Subject: RE: Pharos Quay, River Road, Littlehampton - LU/13/22/PL

The applicant is prepared to agree to remove the boxing in of the eaves, soffits, fascias, bargeboards etc. and the cladding above the doors/to the side of the bin stores and the cladding to the porch canopy roofs from the application in order to secure planning consent for the replacement white PVCu casement windows.

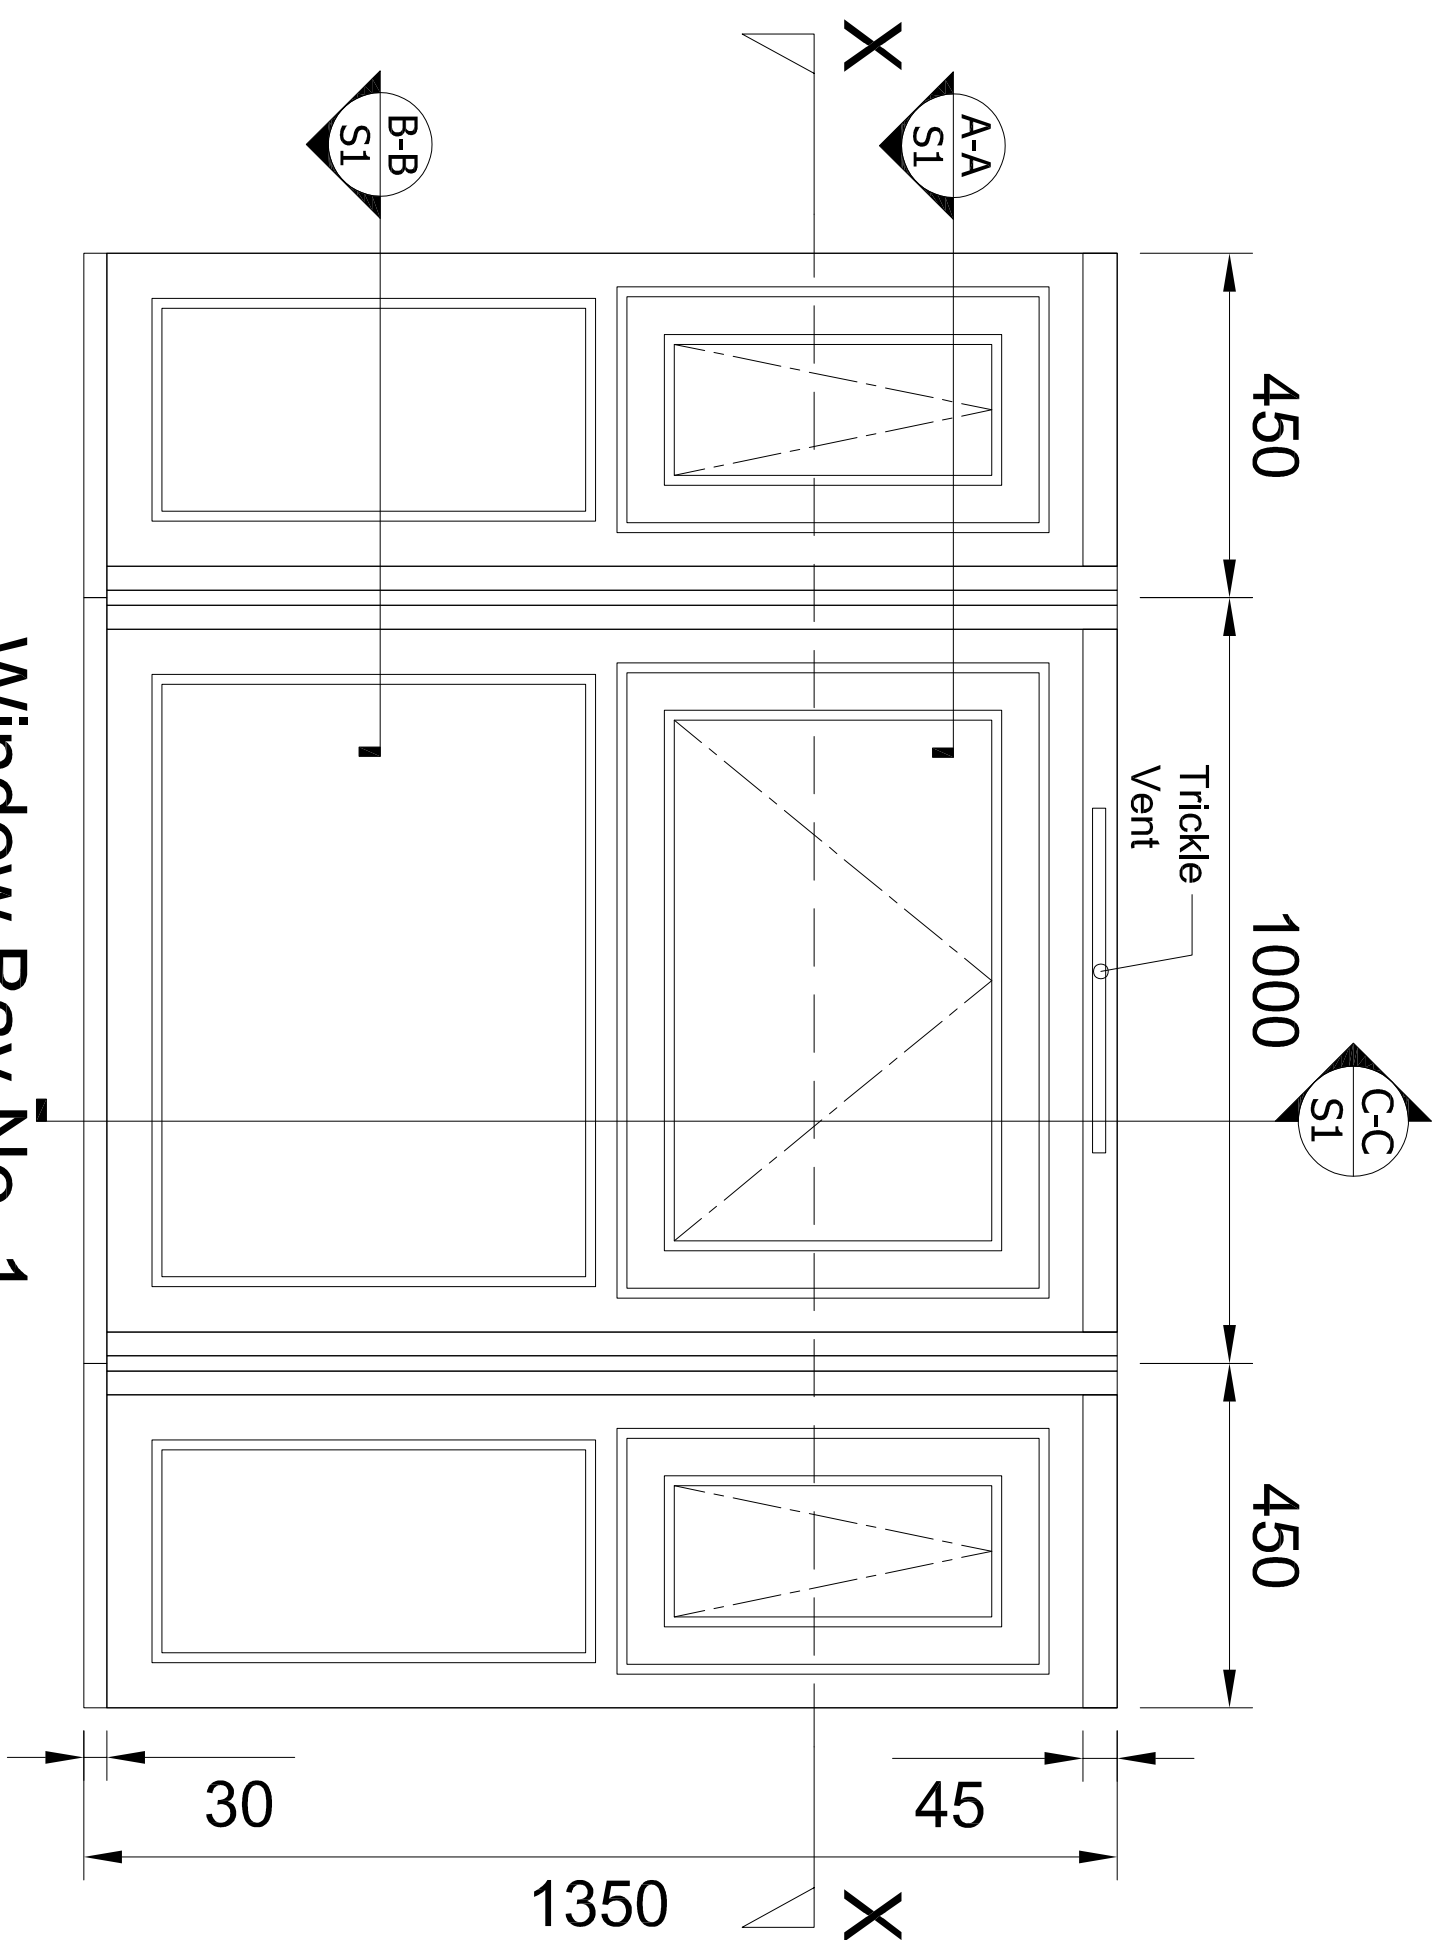
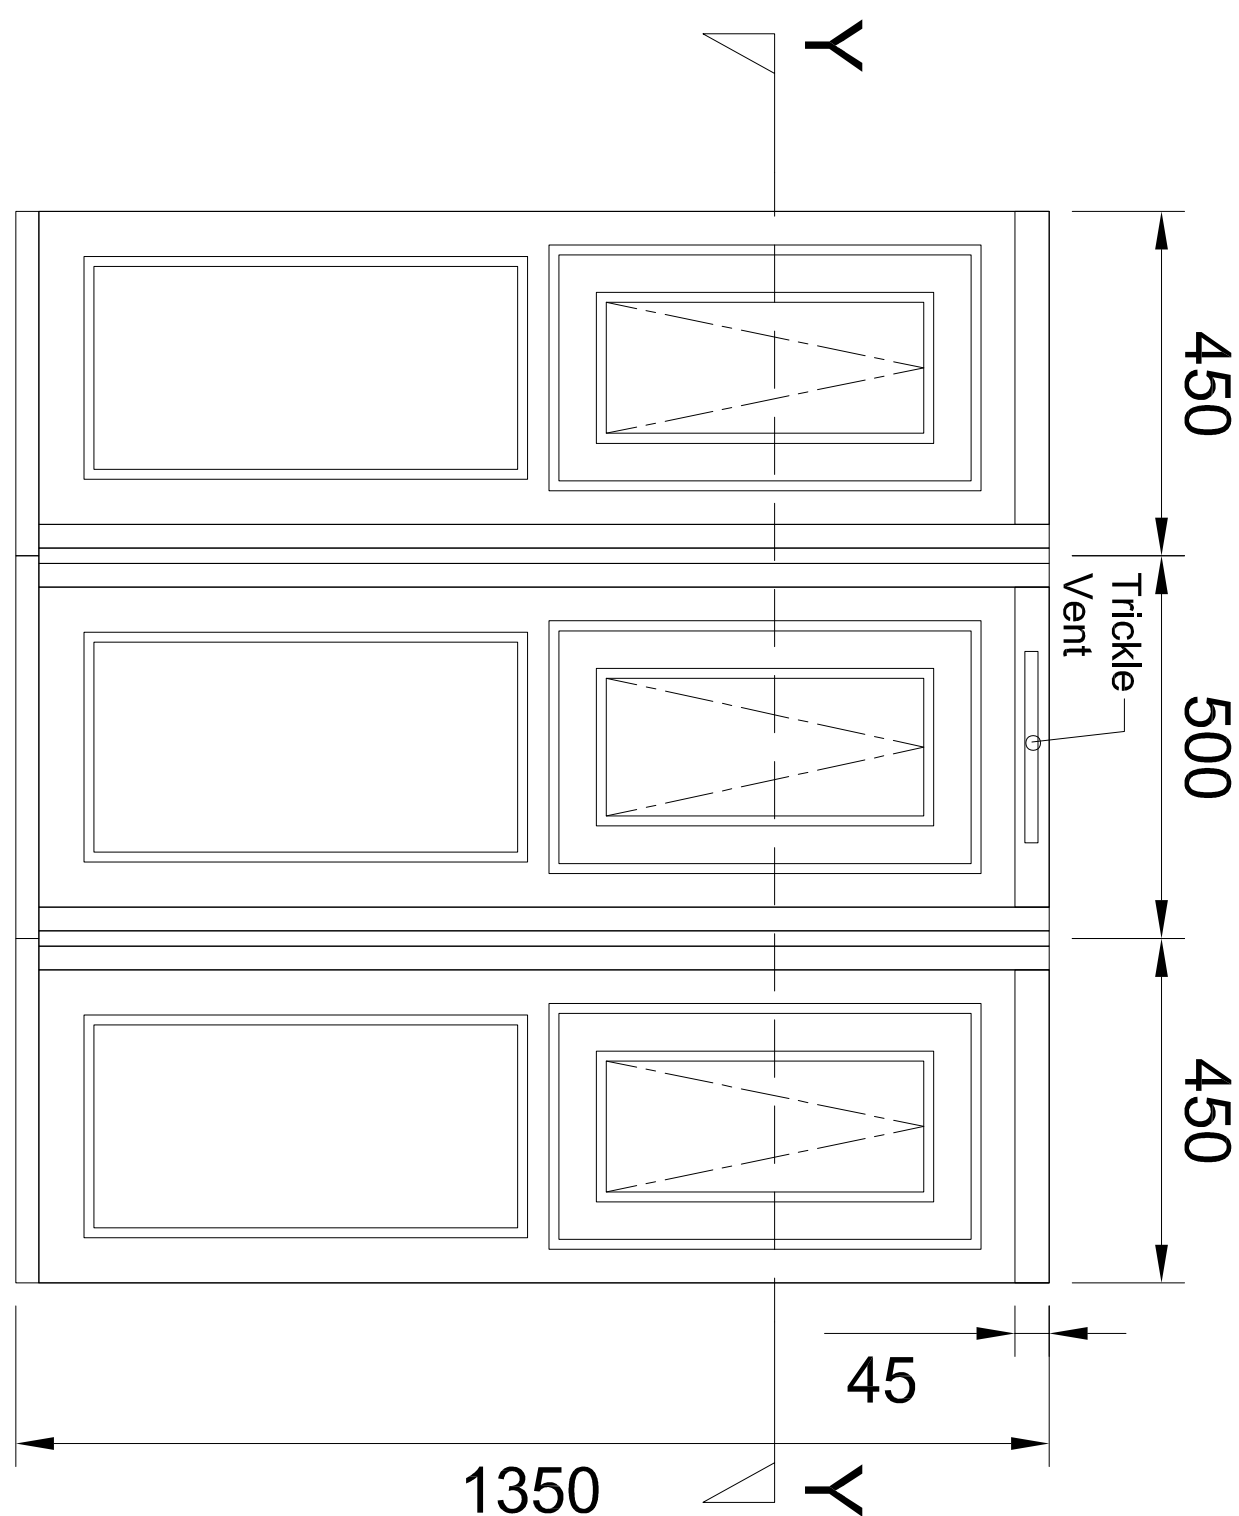
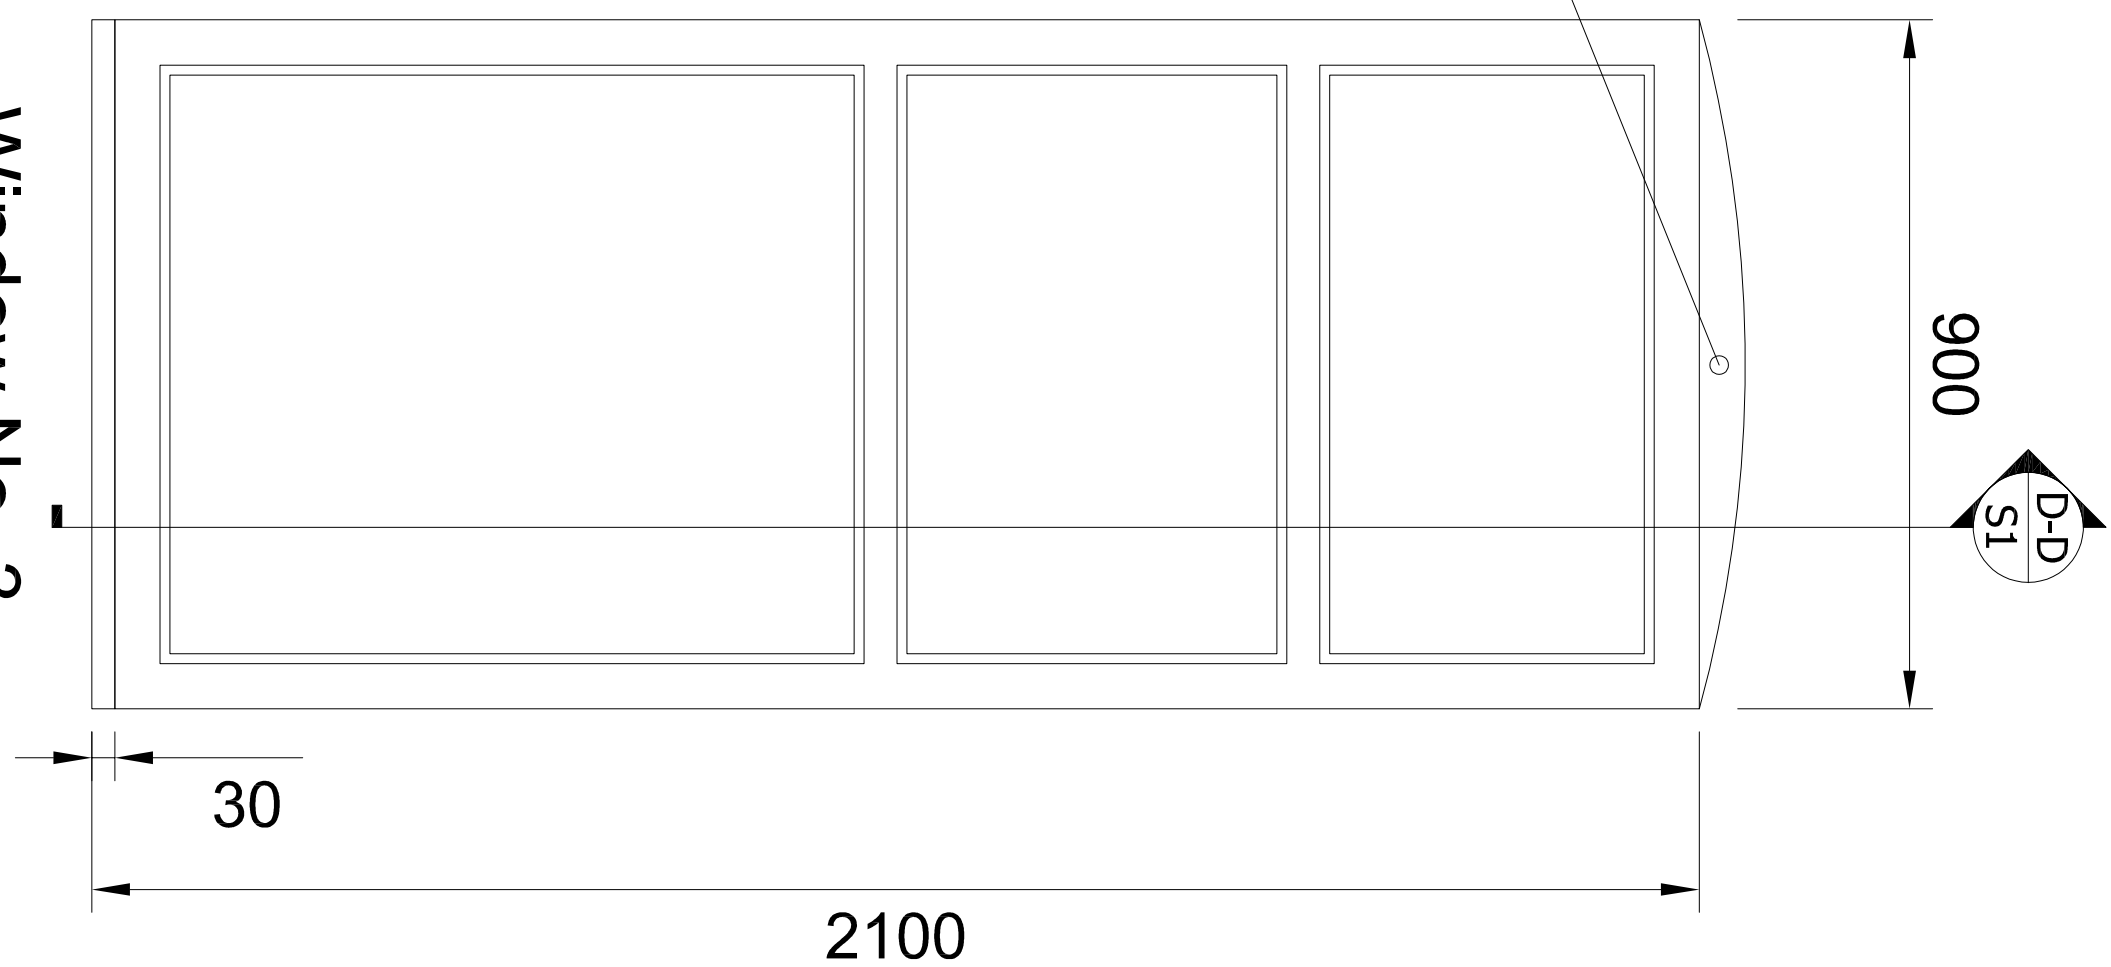
The details sent through for point 4 still look a little 'chunky' to me. As I said over the phone, in order to utilise Upvc windows in heritage locations we normally stipulate heritage glazing, where not only are the glazing profiles slimmer but the frames also. It has been very useful to see the side-by-side comparison, my biggest concern is the upper opening part of the window and not the fixed pane at the bottom, it is significantly larger than the existing timber frame. Is this something that can be rectified? If this can't be done in time I happy to approve with a condition for further details.

3. We discussed advantages of 'horns' on the base of the upper casements but do not feel they add anything to the overall design.
4. I have drafted up a drawing of a typical window (W10) in the existing and proposed format for your assistance. Hope this helps.
